CITY OF ALBUQUERQUE

October 30, 2014

**Re: FedEx Ground ABQ Drainage Report and Grading Plan and Drainage Plan
Engineer's Stamp Date 10-20-14 (K09D026A)**

**RE: FedEx Ground ABQ Drainage Report and Grading Plan and Drainage Plan
Engineer's Stamp Date 9-12-14 (K09D026A)**

RONALD R. BOHANNAN P.E. #7868	FEDEX GROUND ALBUQUERQUE, NM	ENGINEER'S SEAL	DRAWN BY DY
			DATE 7-22-14
	GRADING AND DRAINAGE PLAN		2013075-GRE
	TIERRA WEST, LLC 5571 MIDWAY PARK PLACE NE ALBUQUERQUE, NM 87109 (505) 858-3100 www.tierrawestllc.com		SHEET # GR-3
			JOB # 2013075

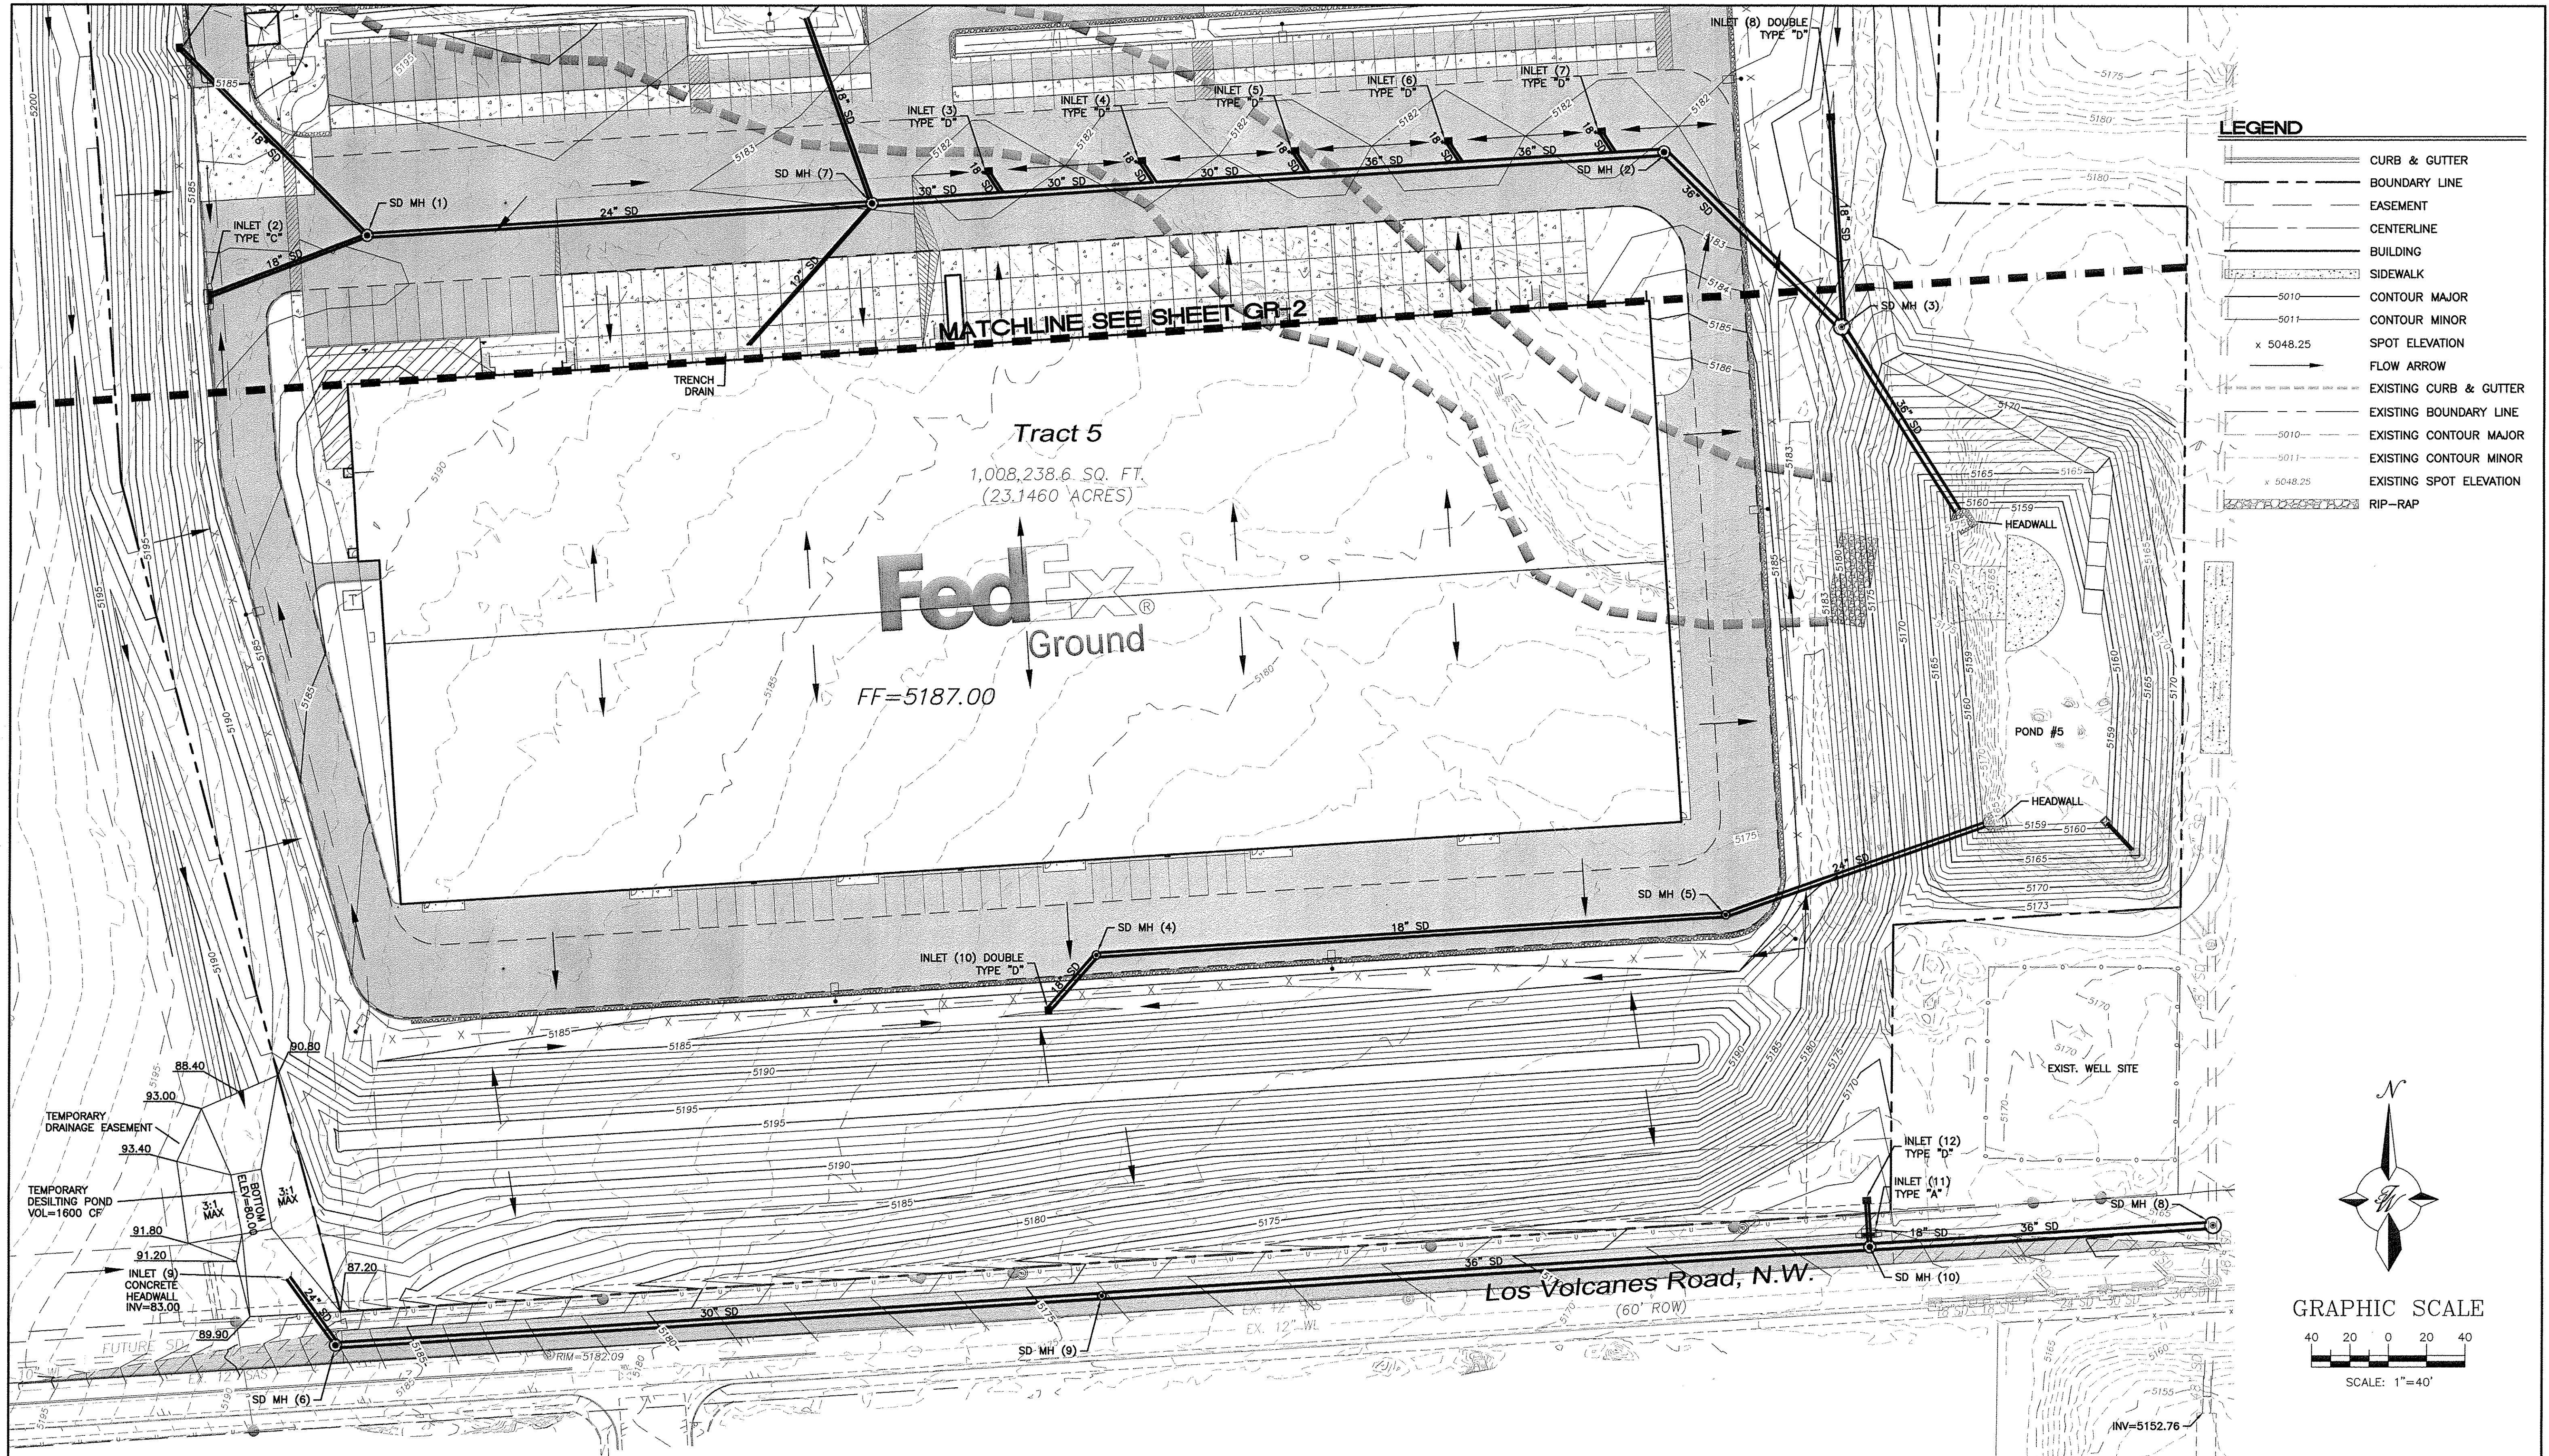
8. Where the 18 inch storm drains connect to the storm pipe north of the building, what are the inverts?

Response: Noted inverts have been added to sheet GR-3.

ENGINEER'S SEAL RONALD R. BOHANNAN P.E. #7868	FEDEX GROUND ALBUQUERQUE, NM		DRAWN BY DY
	INTERIM GRADING AND DRAINAGE PLAN		DATE 7-22-14
	TIERRA WEST, LLC 5571 MIDWAY PARK PLACE NE ALBUQUERQUE, NM 87109 (505) 858-3100 www.tierrawestllc.com		2013075-GRE-INTERIM
	SHEET # GR-4		JOB # 2013075

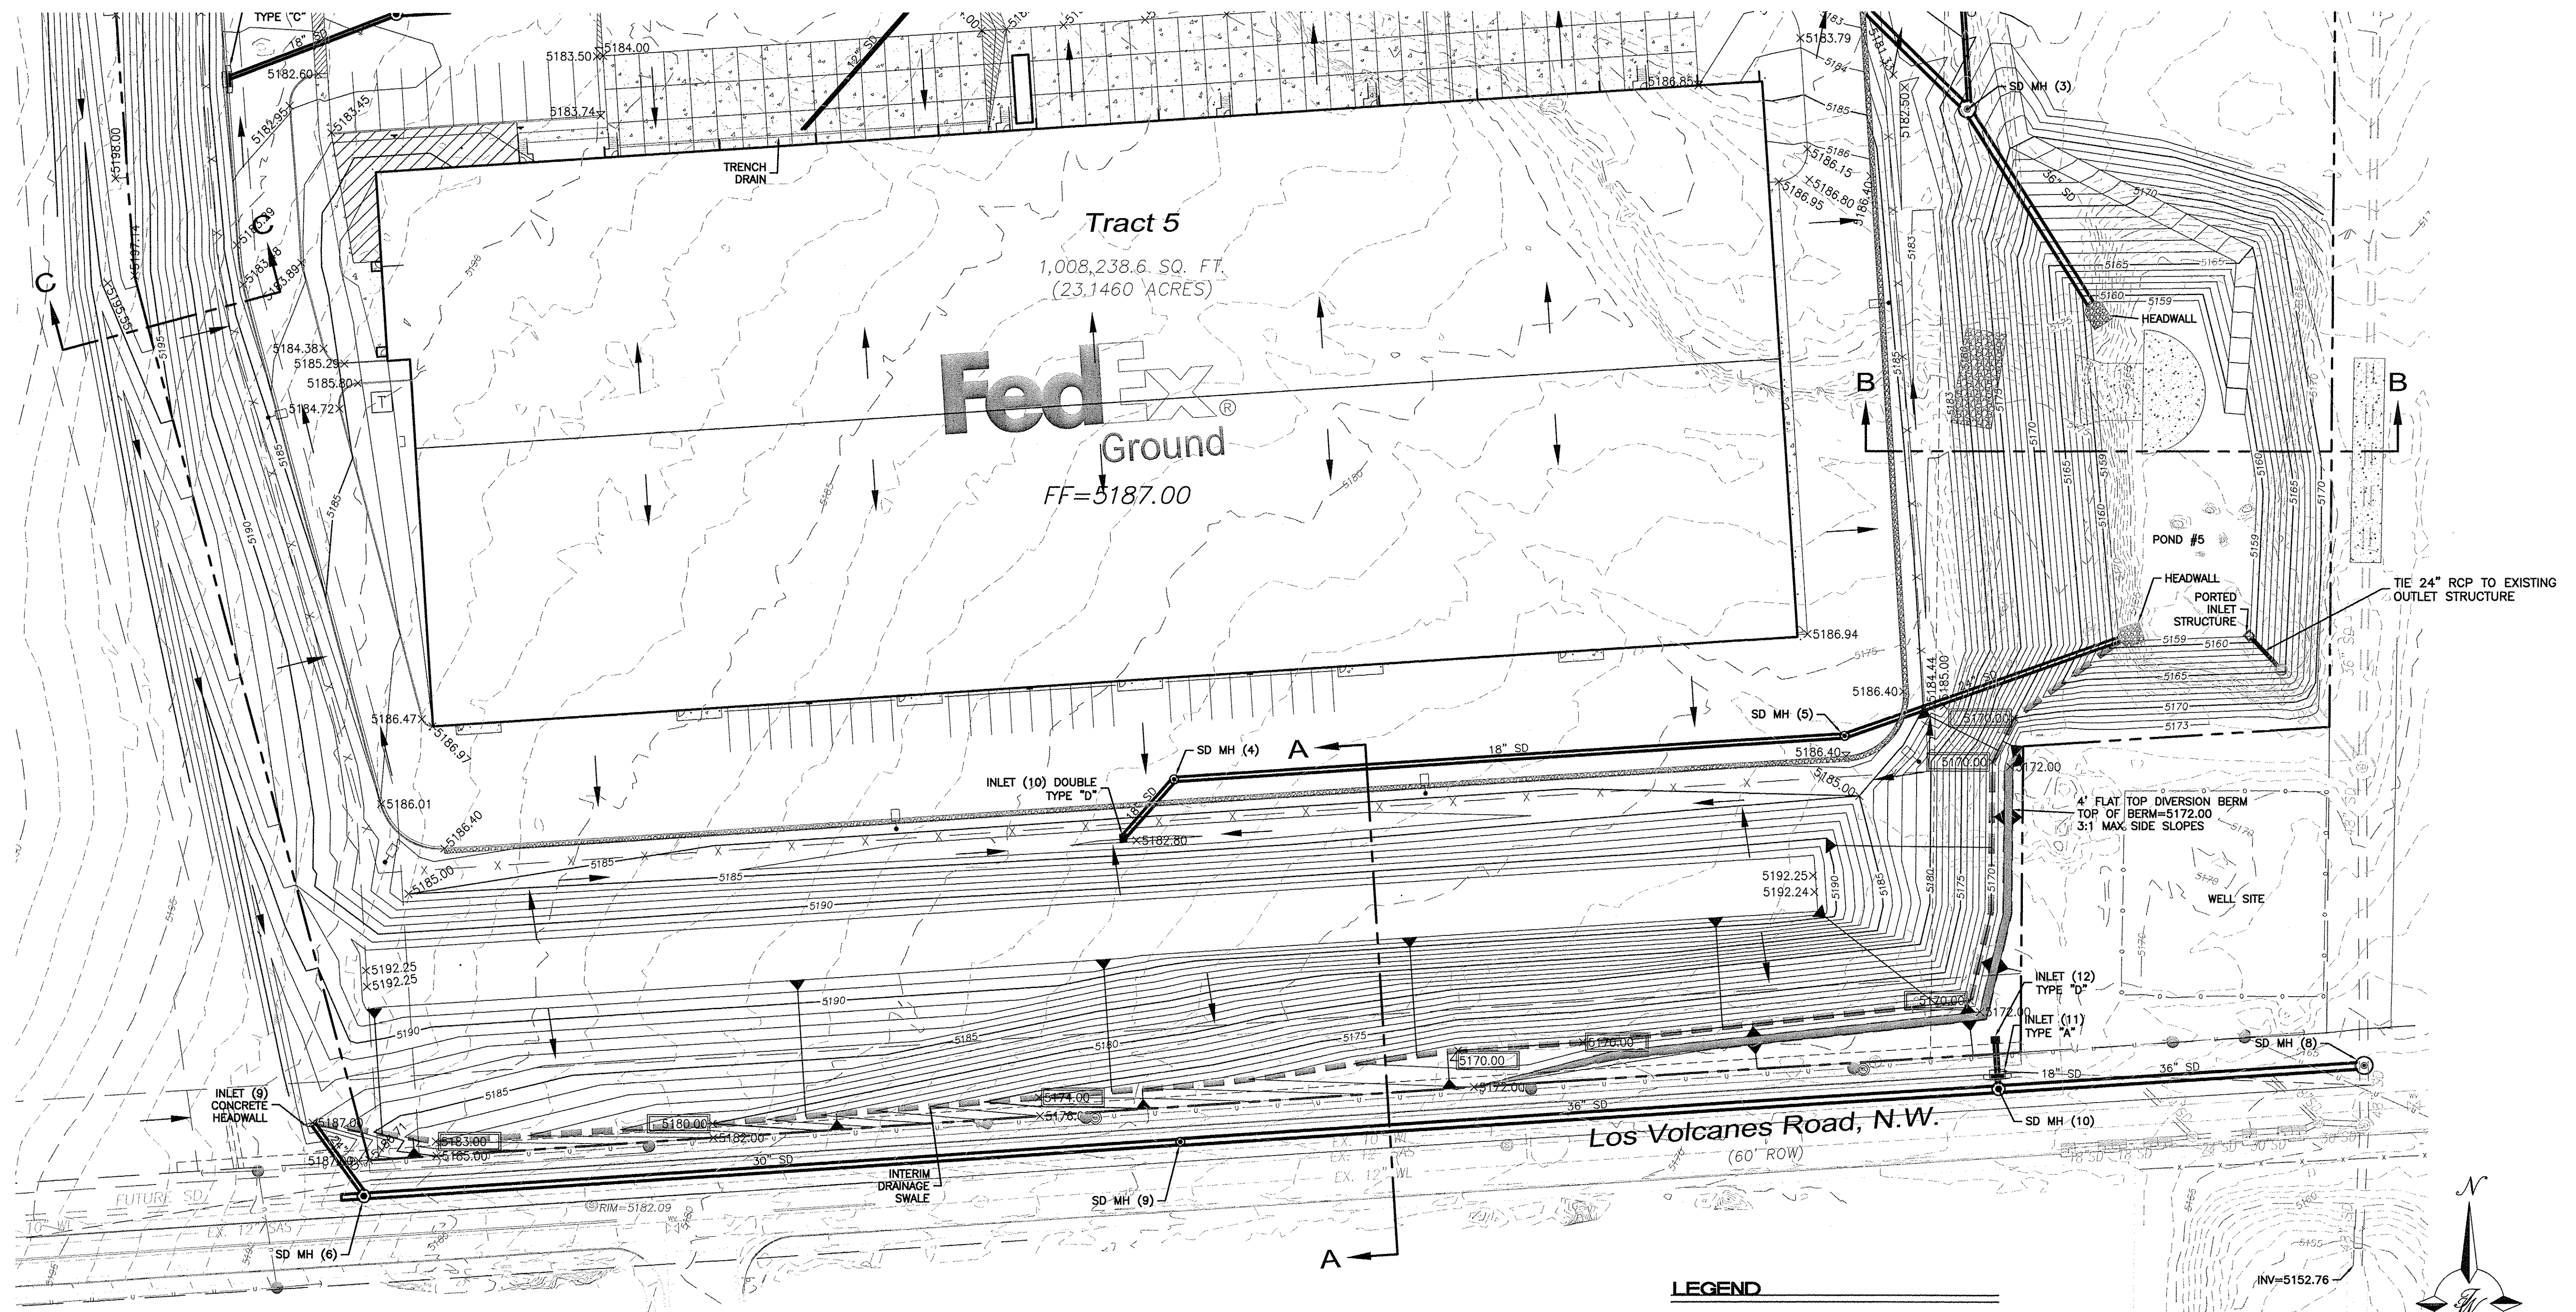
7. Provide a detail (width and size) for the rip-rap along the east and south sides of the parking lot.

Response: A detail has been added to sheet GR-4.
